Waddington Parish Council

Re: Planning application 3/2016/0564 26 Waddow Grove, Waddington

Proposed Site Plan

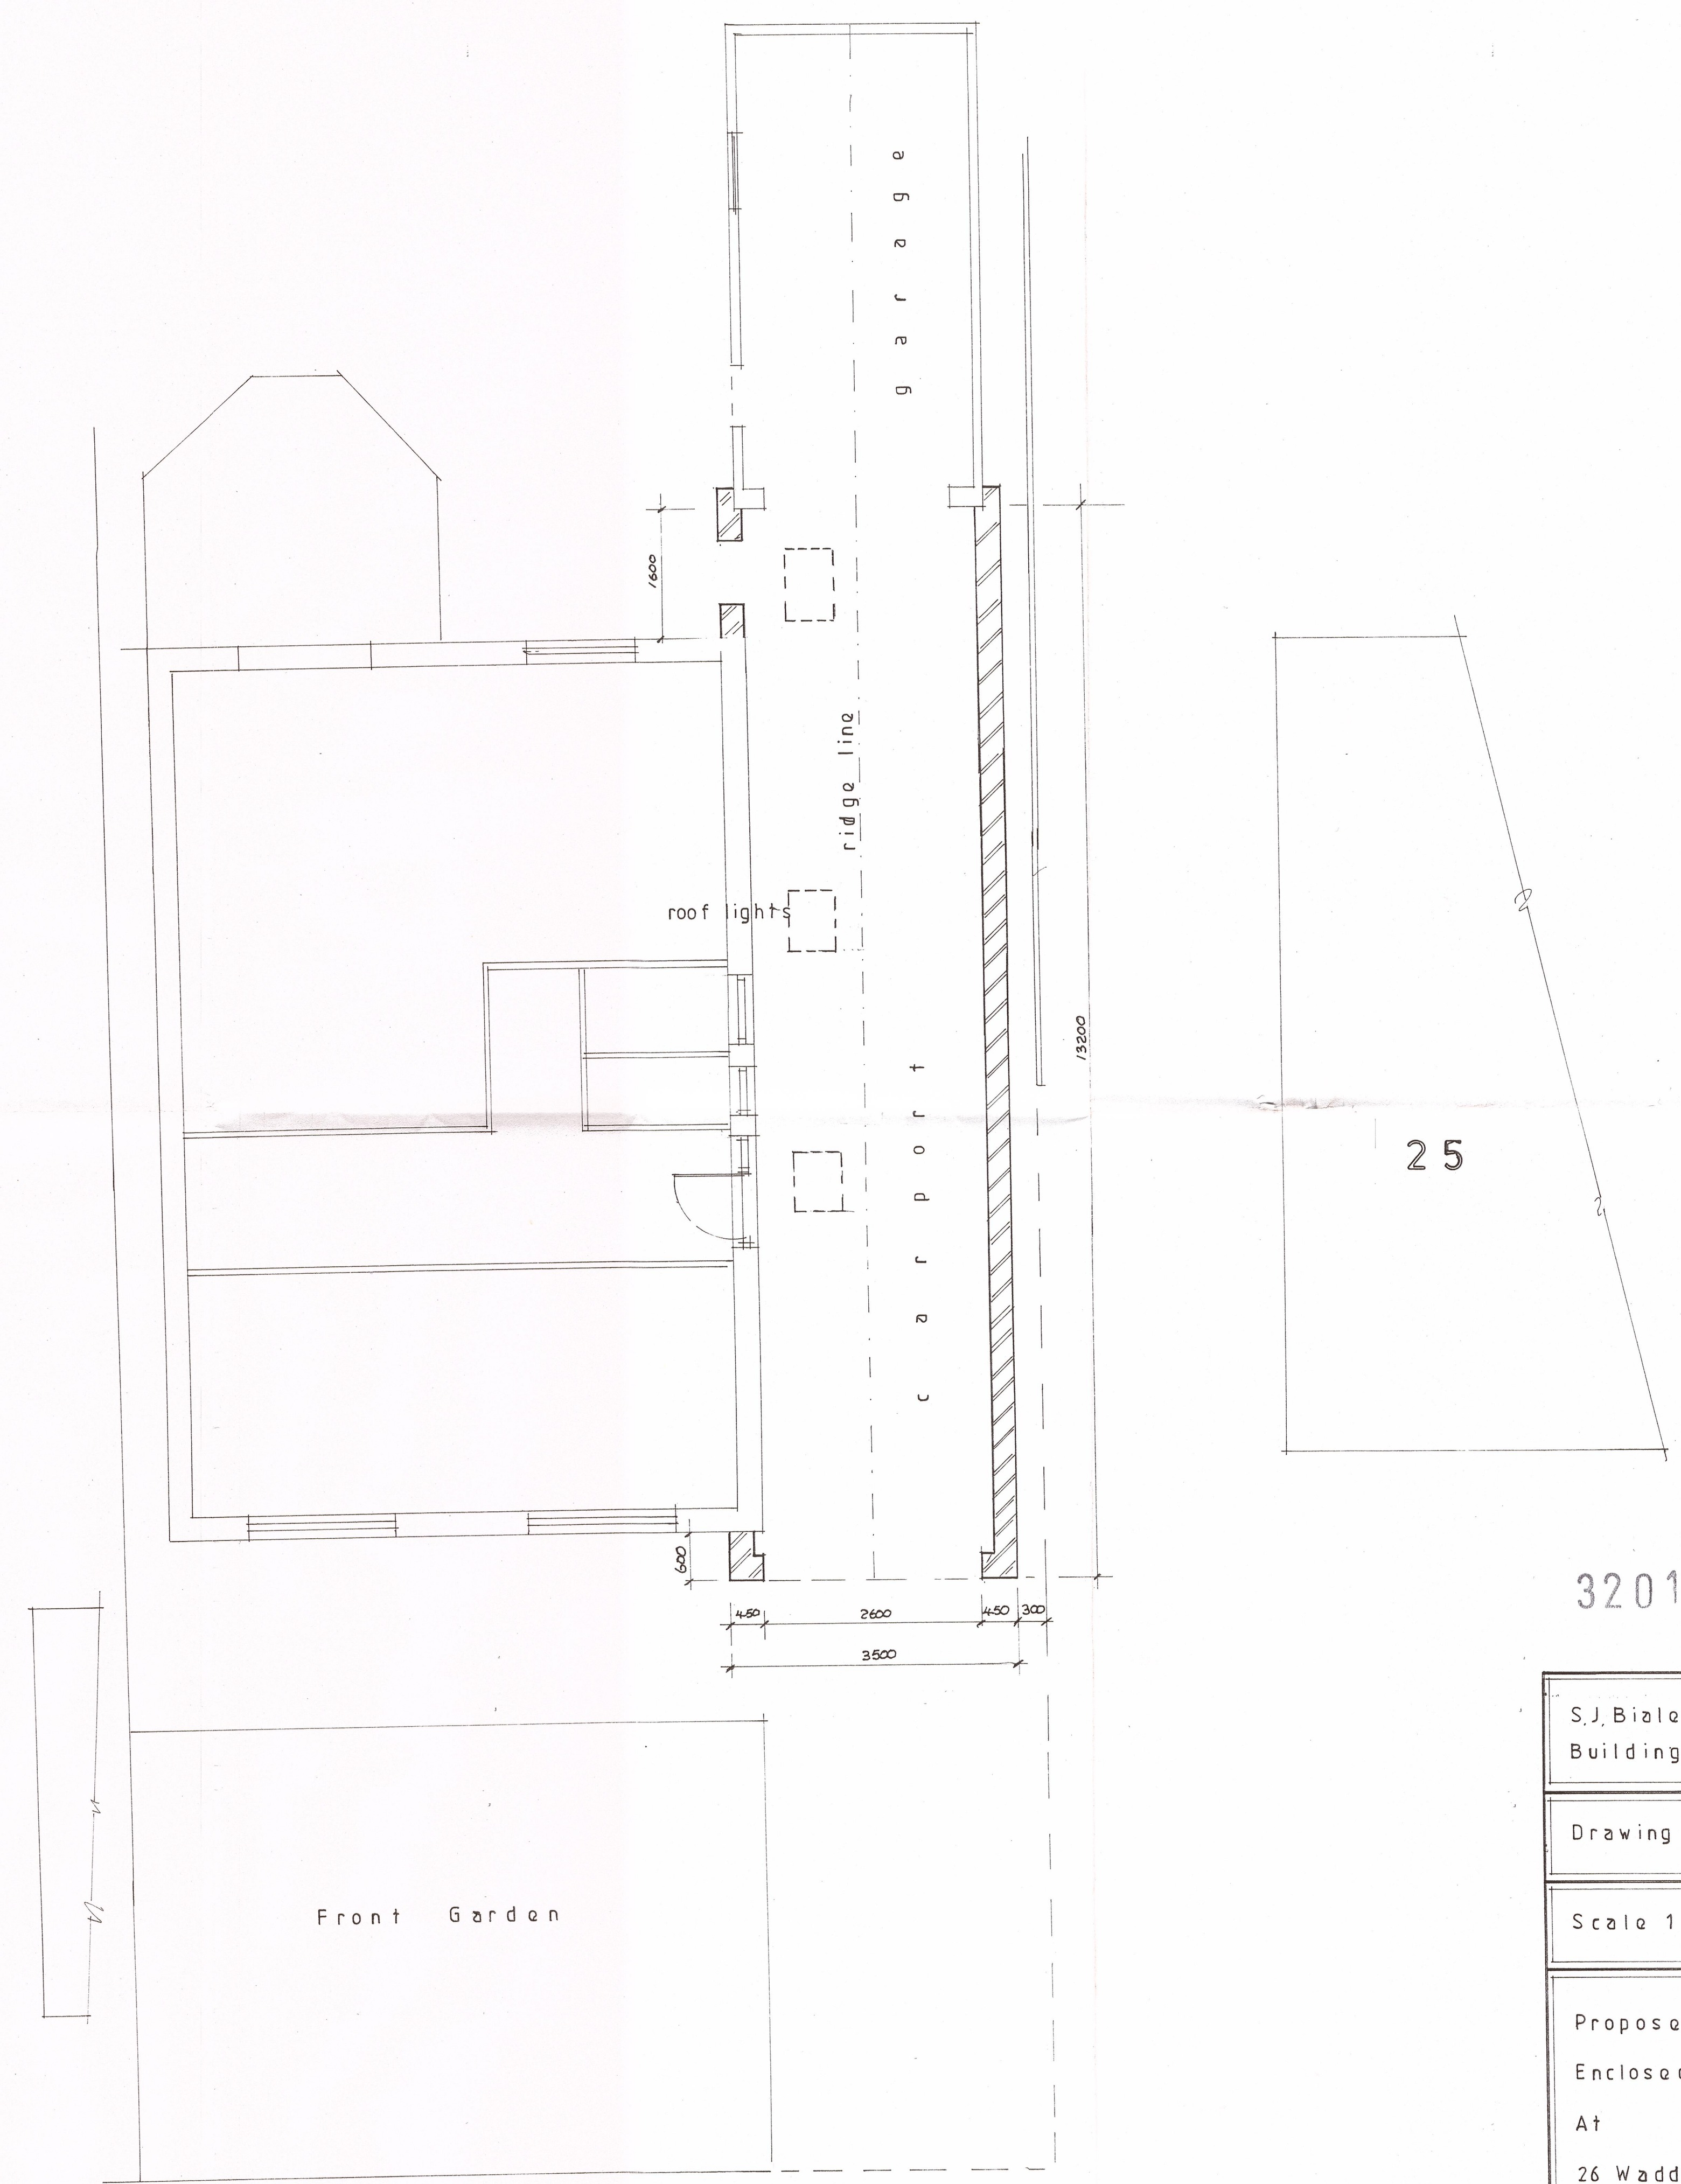
Whilst they have no objection in principle to the enclosed carport, they would recommend that, in order to maintain the consistency of the street scene, that it be set back slightly and not extend beyond the existing property as per the surrounding area.
